From: Shaban, Sundas
Sent: 01 August 2022 12:01
To: _planningadvice
Subject: FW: H23-0618-22 - Olive Tree House
Attachments: IMG_20220729_173805_resized_20220801_081103131.jpg; IMG_20220729_173826_resized_20220801_081102839.jpg; IMG-20210802-WA0001.jpg; IMG_20220729_173909_resized_20220801_081102368.jpg

From: Shaban, Sundas
Sent: 29 July 2022 15:21
To: Harley Cooper
Subject: H23-0618-22 - Olive Tree House
Importance: High

22-P23-PL004E

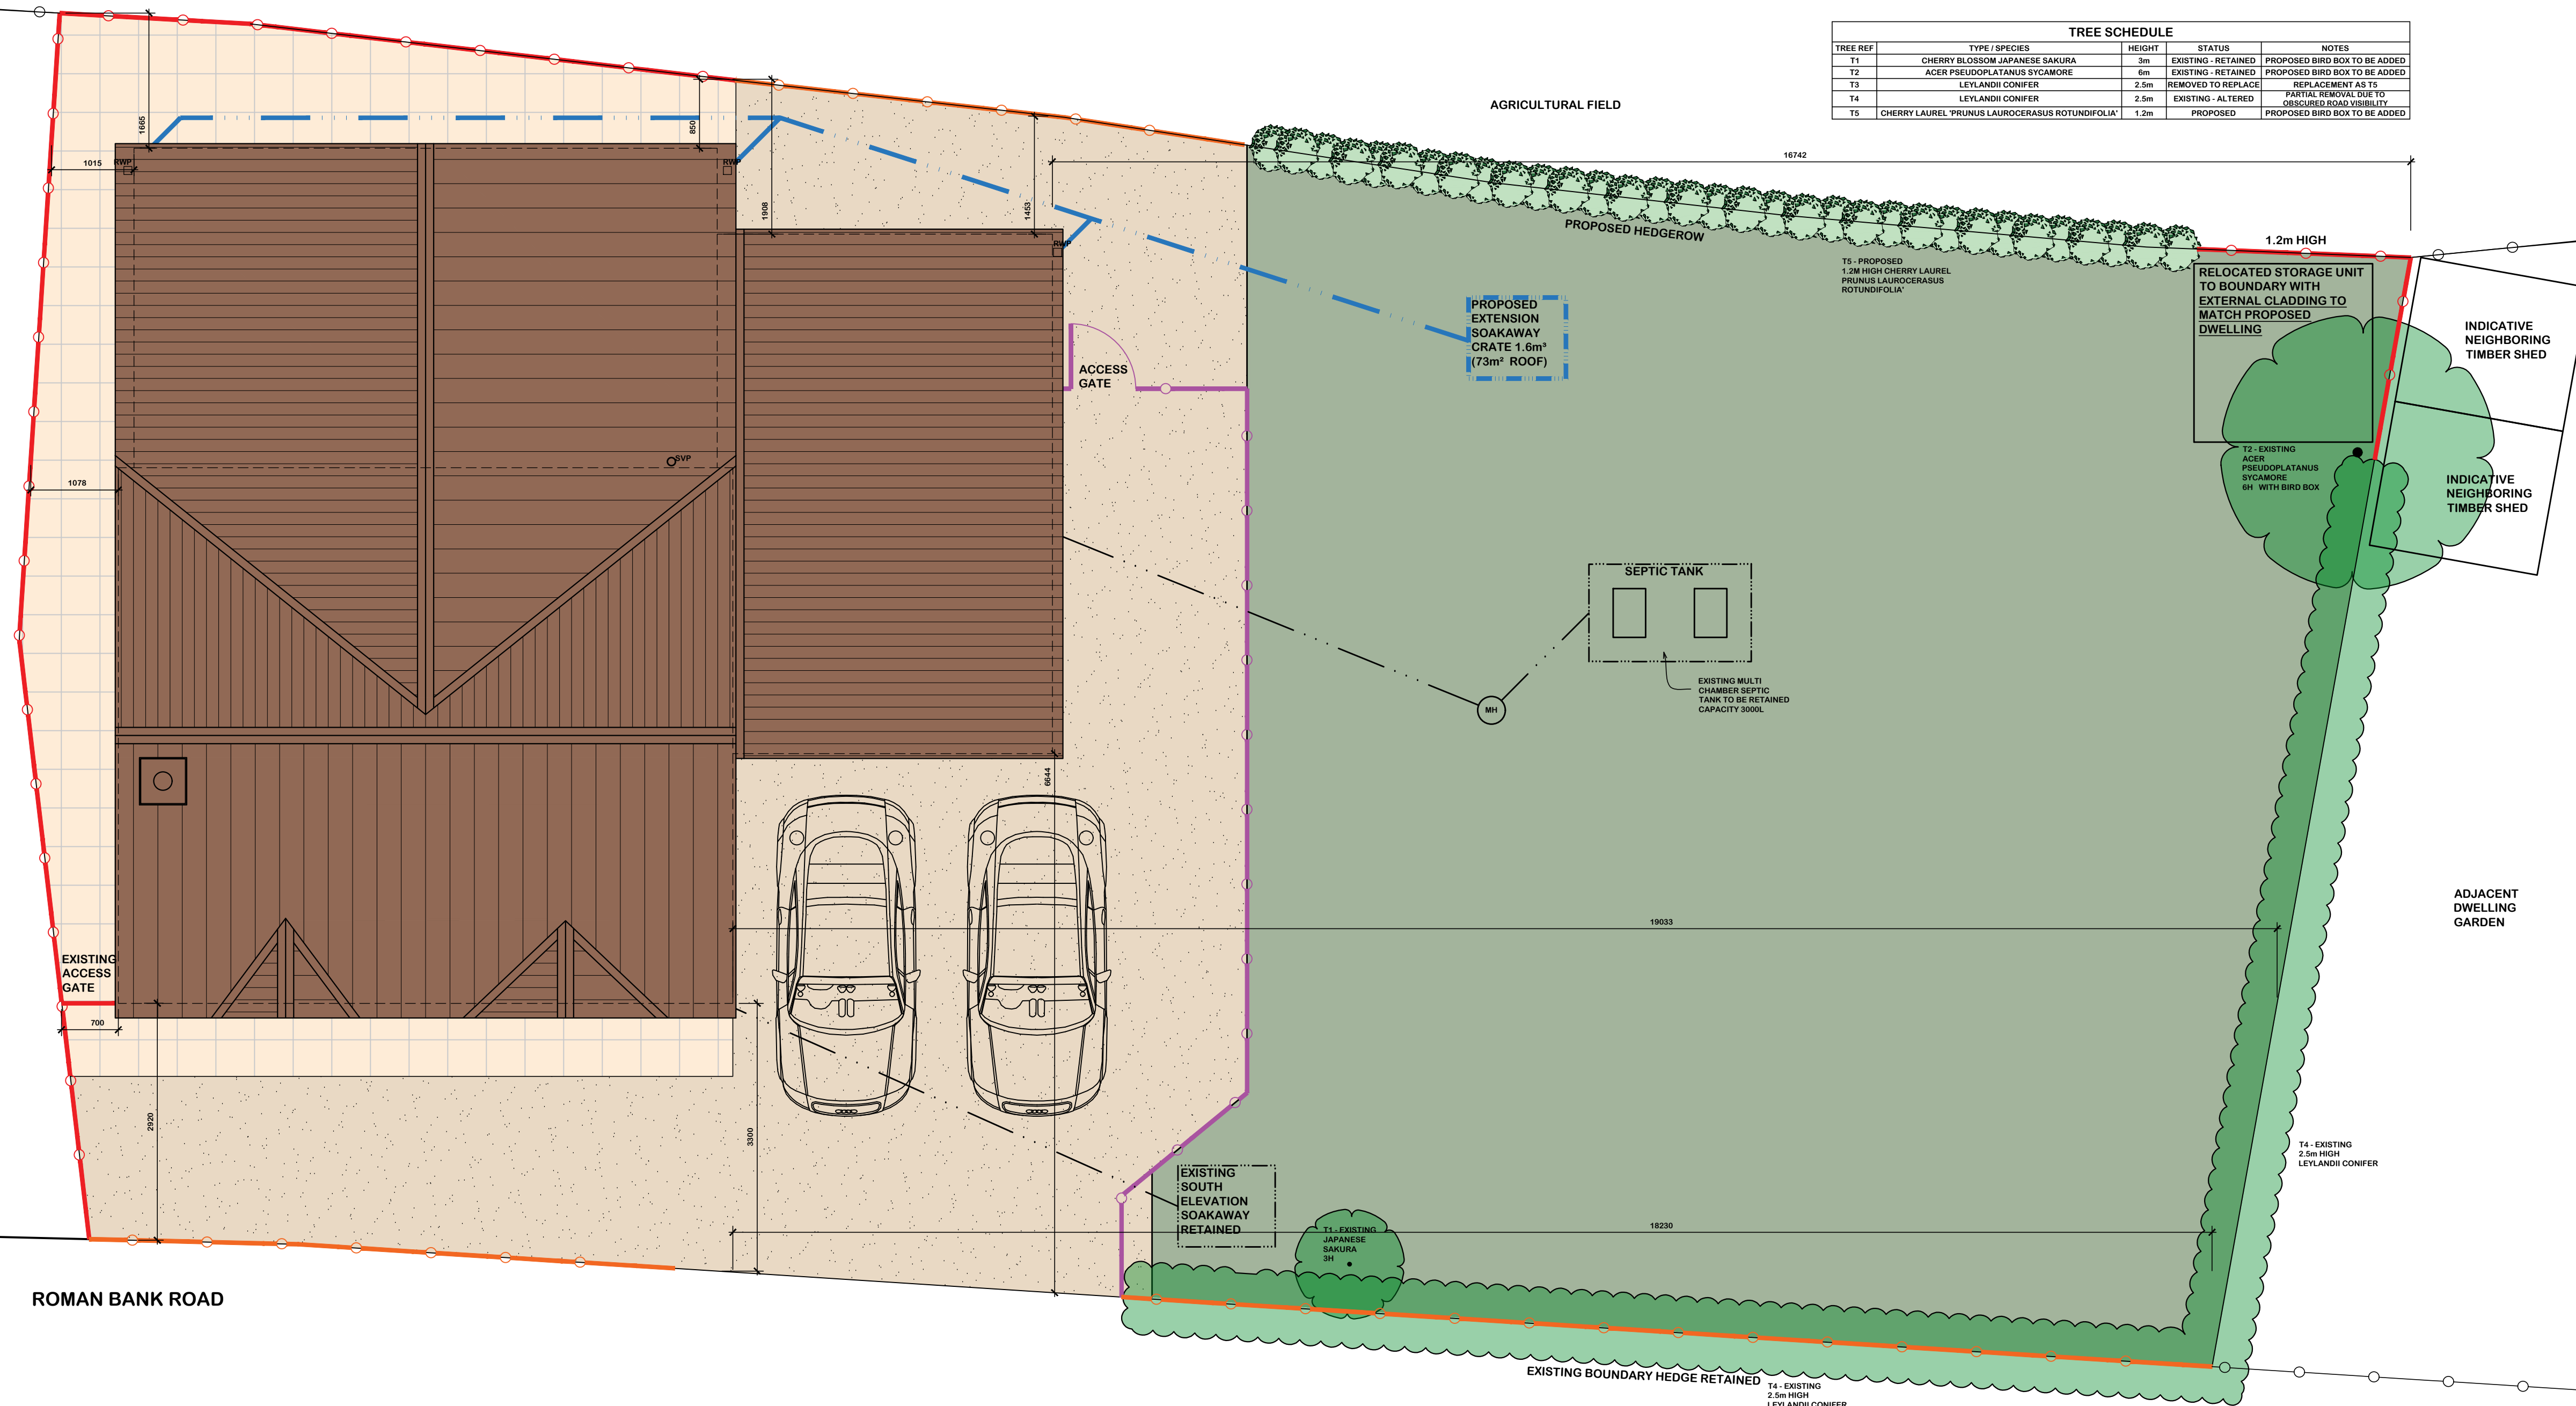
Can you please confirm the size of the structure?

My understanding is that it would be on the site long term? Is this not that case?

Temporary structures are allowed for up to 28 days.

Further to the above application please can you provide dimensions of the storage container proposed to be relocated and photos of the container and the eastern site boundary where the container would be located?

Size has been measured over the weekend as 8ft (2489mm) deep, 6ft 7ins wide (2000mm), 6ft 7ins (2000mm) high. Photos attached of the proposed area which includes the neighbouring sheds in view, obviously suitable preparations to the ground and pruning of the existing confers will be required to position.

As you can see this will back onto the neighbouring sheds/fence and an agricultural field, much as it does already on the other side of the plot and yes the structure will be retained on the plot in lieu of a timber shed and we believe the location proposed is best suited to the plot.

Please see photo of the container which is a standard small type 8ft x 7ft x 7ft high (set into the ground) finished in brown. As mentioned previously the lack of visibility from the road due to conifers and the neighbours existing sheds/fencing would not cause any detriment to the current area.

I can look to obtain a photo of the proposed area although I would first like to query if the container relevant to the overall application? Typically containers are considered a temporary structure which in my experience does not require planning permission and would not form part of the determination process for a separate permanent structure.
